From: Finlay Gardner <Finlay.Gardner@arun.gov.uk>
Sent: 15 February 2021 17:45
To: Planning.Responses <Planning.Responses@arun.gov.uk>
Subject: FW: Flamsteed - BN/2/21/DOC

Having looked at the application the drainage engineers require further information. There are 5 points please see below:

| Project number | FLA-19            | D102          |

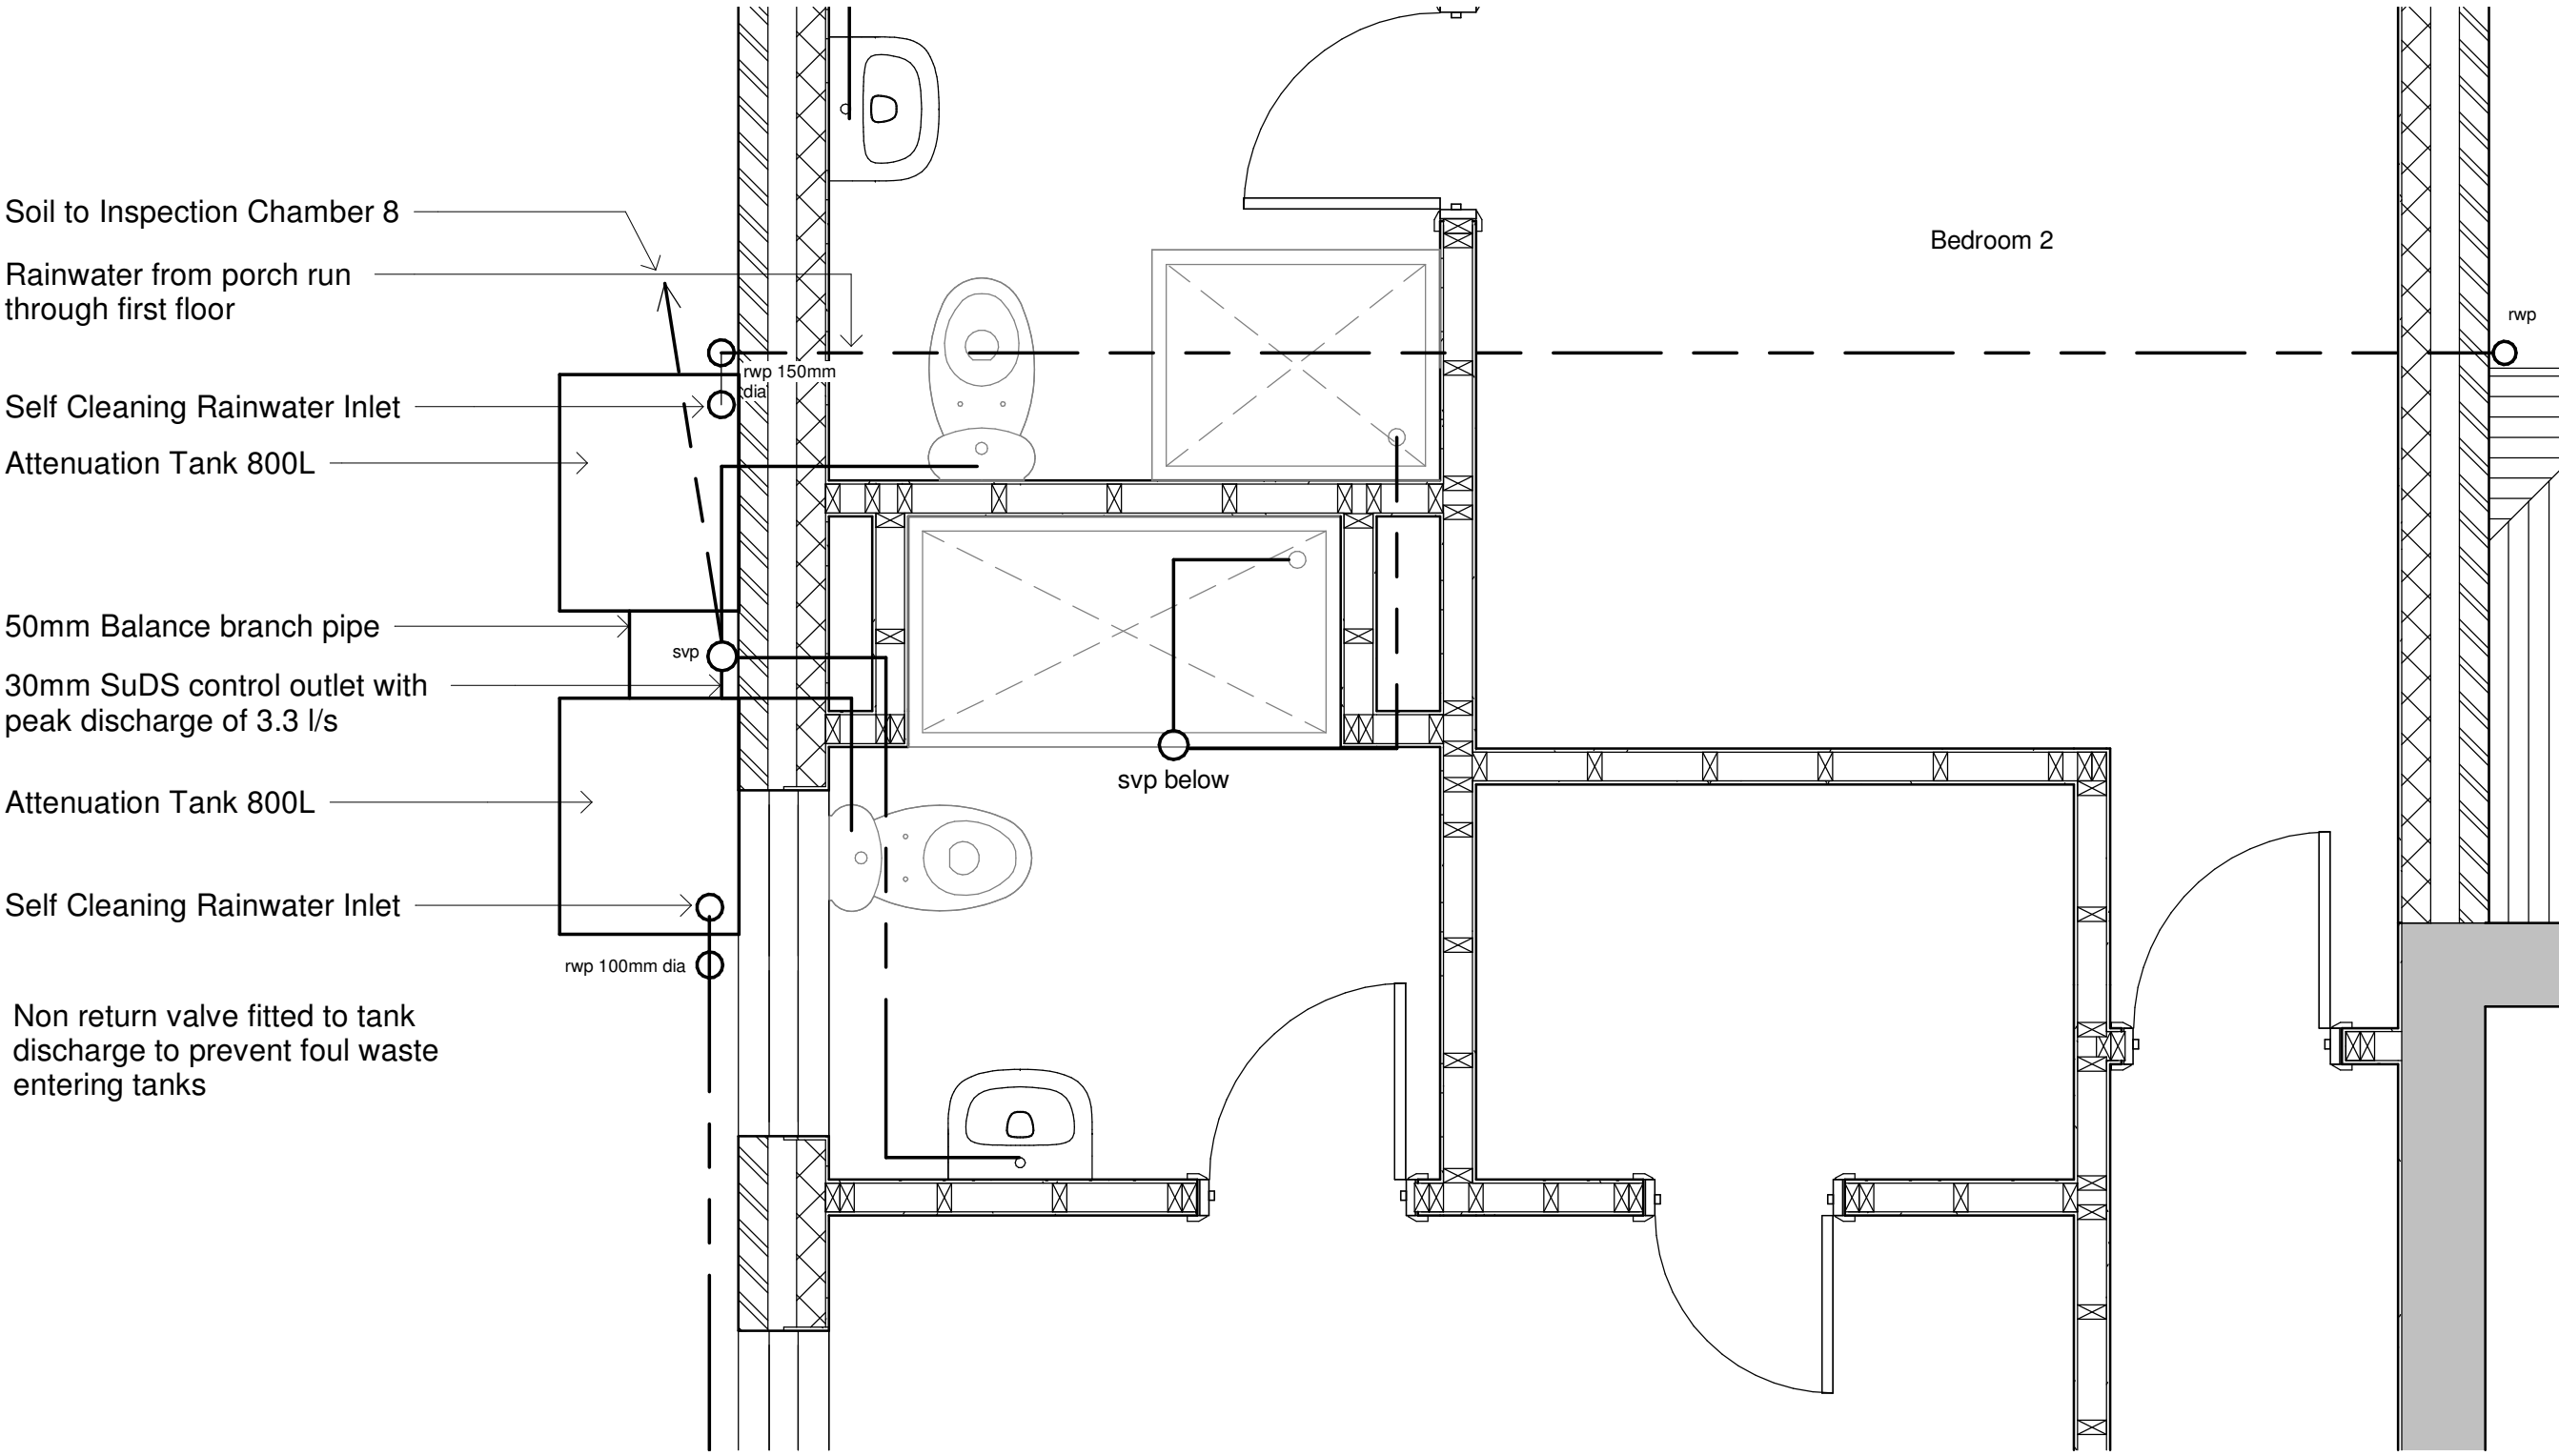
2. Please confirm that there are only two rainwater pipes on the property post development. I know they are shown on the elevations but also need to be included on drg. D102.

4. The notes on drg. D102 reference the use of soakaways – note needs to be removed.
5. Add pipe gradients to drg. D102 for the combined pipework ie. for each length. Manhole cover levels for the combined system should also be provided (with the invert levels relative to these).

2. The two rainwater pipes were required on drawing D102. These are on D102, wrong drawing sent. See comment 4 below.

4. The notes on Drg D102 references the use of soakaways and should be removed. You are correct, I sent the wrong drawing back, please find attached the updated Drawings D102

5. All levels and falls are on D102, they were on the version you had previously.
